Mr Nicholas Dowman
Senior Planning Advisor
Health Infrastructure
1 Reserve Road
St Leonards NSW 2065
13/01/2022

**Concord Hospital Concept Proposal & Stage 1 Modification 7 (SSD-9036-Mod-7) –
Changes to parking, ESD and Landscaping – Request for additional information**

**LANDSCAPE PLAN
MULTI STORY CARPARK**

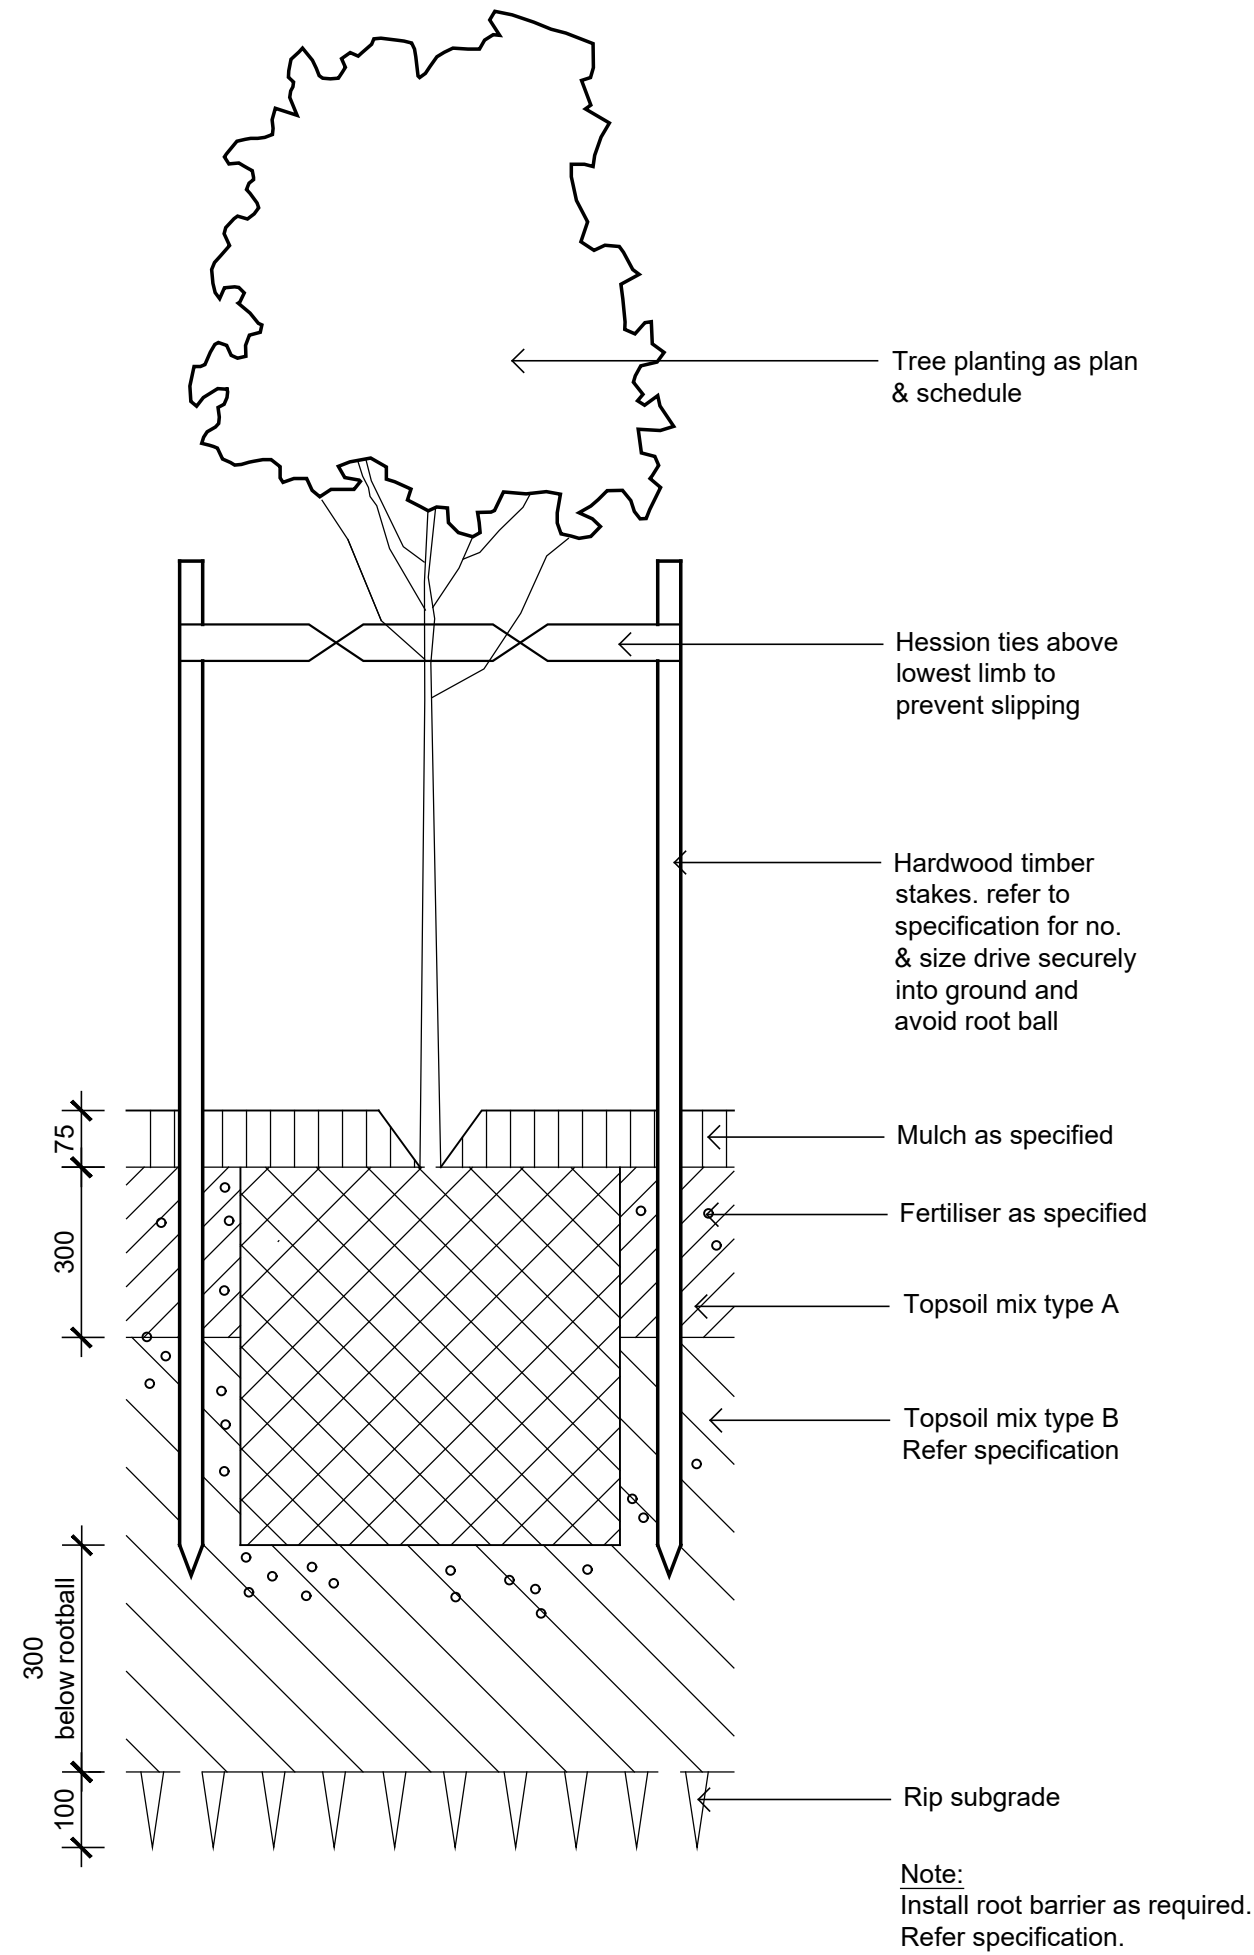
- Clarification on the discrepancy between the number of at-grade spaces impacted by the multi-storey carpark construction (208 in original approval and 207 under subject modification).
- ESD conditions **B22**, **B23** and **C43** must be updated to ensure the multi-storey carpark attains compliance with the Health Infrastructure Engineering Services Guidelines (incorporating Design Guidance Note No. 058), in accordance with recent health infrastructure approvals. Or alternatively outline the reason this would be unfeasible.
- Confirm that condition **D26** for tree replacement can be amended to include a reference to the selection of local native vegetation communities and investigate the opportunity to increase the tree replacement ratio above the current rate of 1:1.
